# **Gatwick Northern Runway**

**TR020005**

## **National Highways Comments on any Submissions Received by Deadline 1**

March 2024

Figure 1: Location of Contractor Compounds

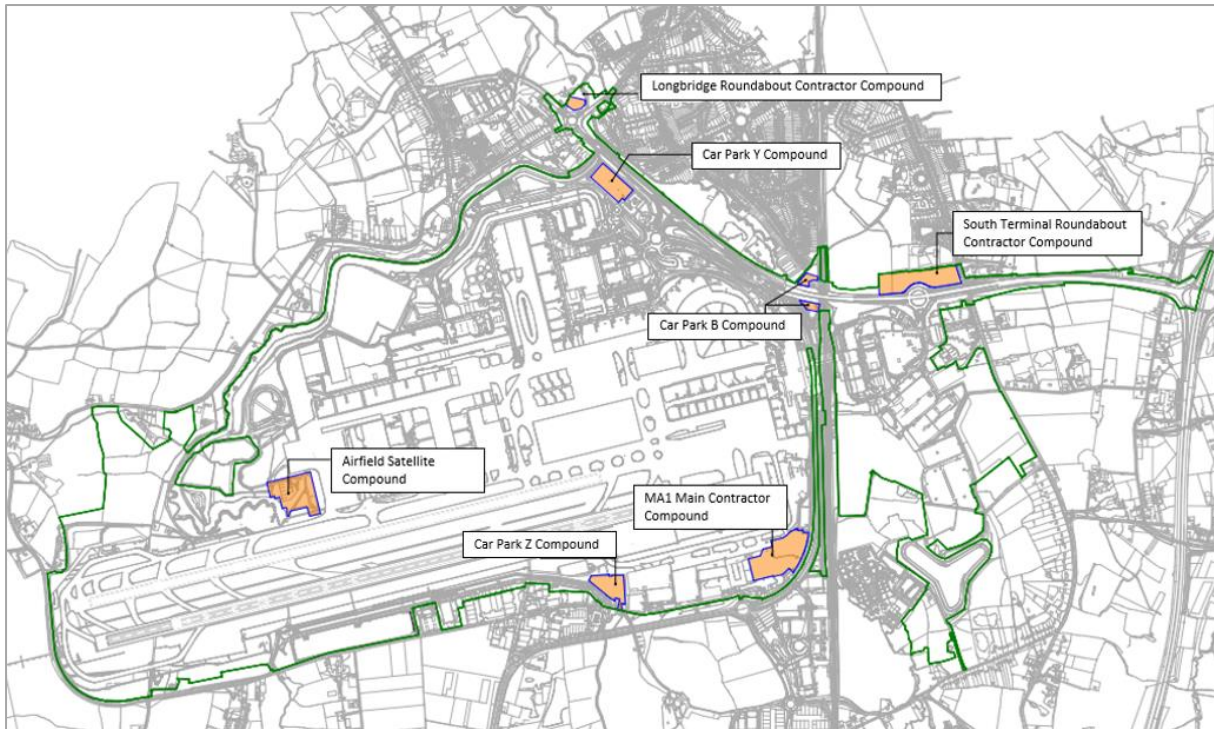
Section 4.2	REP1-212	The Authorities have a particular concern as to how the works for the contractors' construction compound, which sits to the north of the southern roundabout works (as shown in figure 5.2.1.f in PDLA-008), impacts on a proposed Local Plan allocation for a business park in Reigate and Banstead. Currently, the Authorities see the two as incompatible which is unacceptable because the construction compound frustrates the ability to bring forward an important Local Plan allocation. In general terms, the Authorities would note that there is a need for a greater degree of specificity across Schedule 1 and specific concerns in relation to timing are further detailed in the Authorities respective LIRS.	<p>National Highways engagement with the Applicant regarding the safe operation of a construction access off South Terminal Roundabout remains ongoing. National Highways will engage on any longer-term proposals for the land through the local plan consultation/formal process.</p> <p>The Applicant provided a technical note with further information; however, National Highways have not yet received a response to comments raised. The Applicant has not sufficiently demonstrated how the construction traffic impact on the Strategic Road Network has been used to inform the decisions in relation to preferred location sizes and uses for the construction compound, and it can be operated safely. These matters need to be addressed to the satisfaction of National Highways before they are considered resolved in both National Highways' Principal Areas of Disagreement Summary Statement [TR020005/RR/3222] and the Statement of Common Ground with the Applicant [TR020005/REP1/036].</p> <p>National Highways will continue to monitor the concerns raised by other Statutory Bodies in the event that any other concerns may need to be escalated in National Highways submissions</p>
